Application for a Non-Material Amendment Following a Grant of Planning Permission

The development proposed was described as 'construction of a detached building to accommodate commercial floorspace at ground and first floor levels and 3 x 1-bedroom / 1-person flats at 2nd, 3rd and 4th floor levels at the land to the rear of 42-48 Windmill Hill'.

74574/APP/2019/431

The following non-material amendment application seeks permission to alter the materiality of the previously approved front elevation of the new development at 42-48 Windmill Hill.

Proposed Front Elevation - Drawing 053-A-55

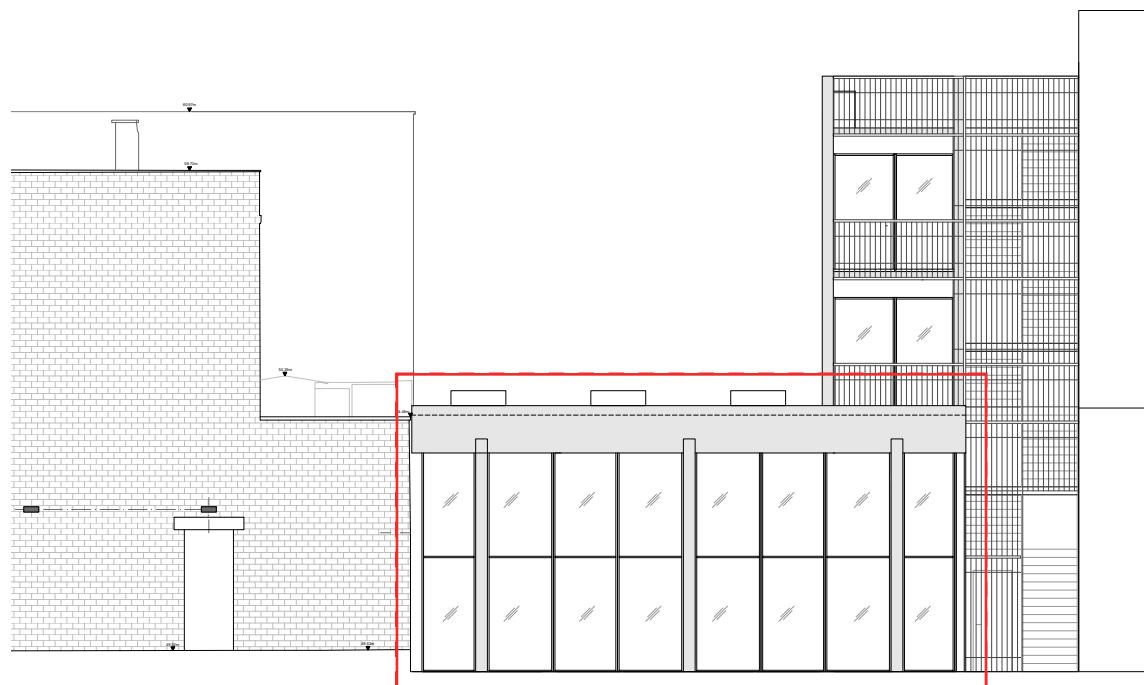
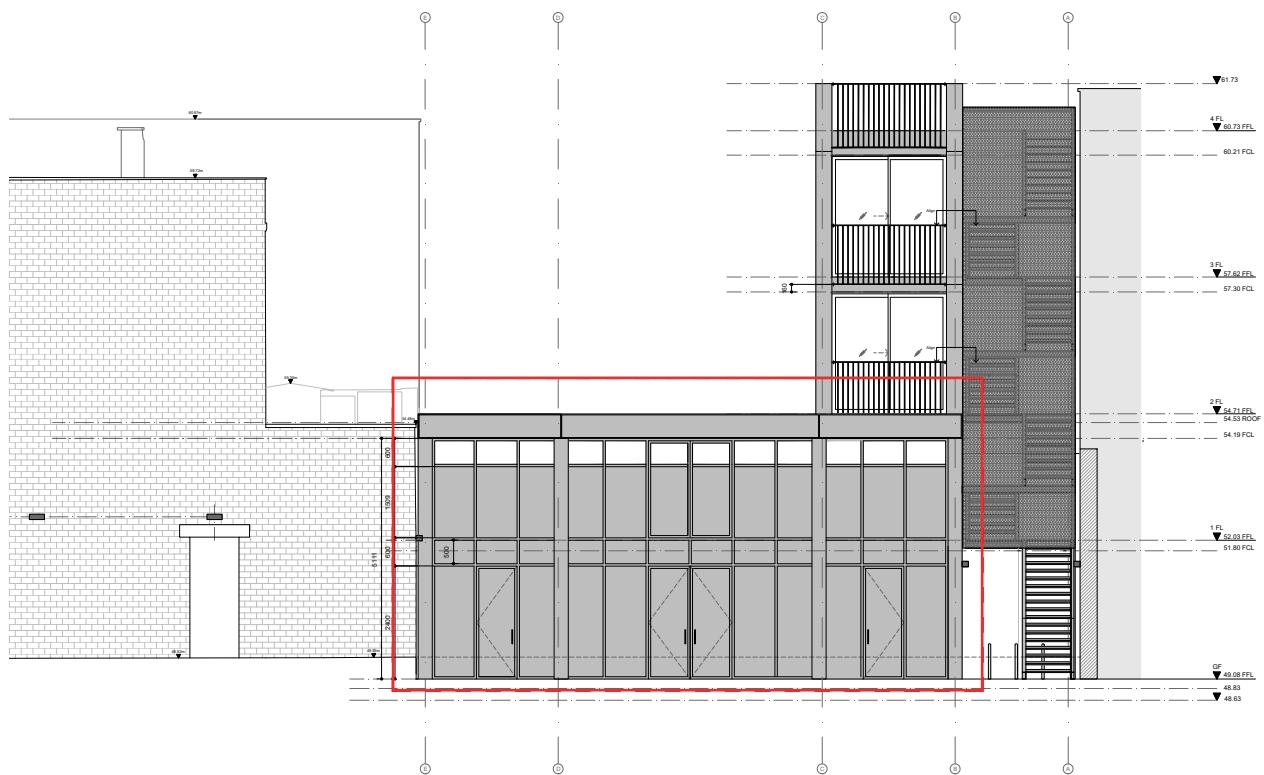
A black aluminium, glazed curtain walling system is still proposed however, we seek to reduce the amount of glazing within the front elevation replacing this with black aluminium panels. This change is sought for the purposes of privacy, security and the reduction of heat loss.

The site and development is flanked by tall buildings to all sides with the interior of the garage and show room being seen from all neighbouring buildings. Due to the nature of the buildings purpose (motorbike garage and showroom) it requires a high level of privacy and security to safe guard expensive stock kept on site.

Through the reduction of glazing and the replacement of solid insulated panels the amount of heat lost through the façade will be significantly reduced.
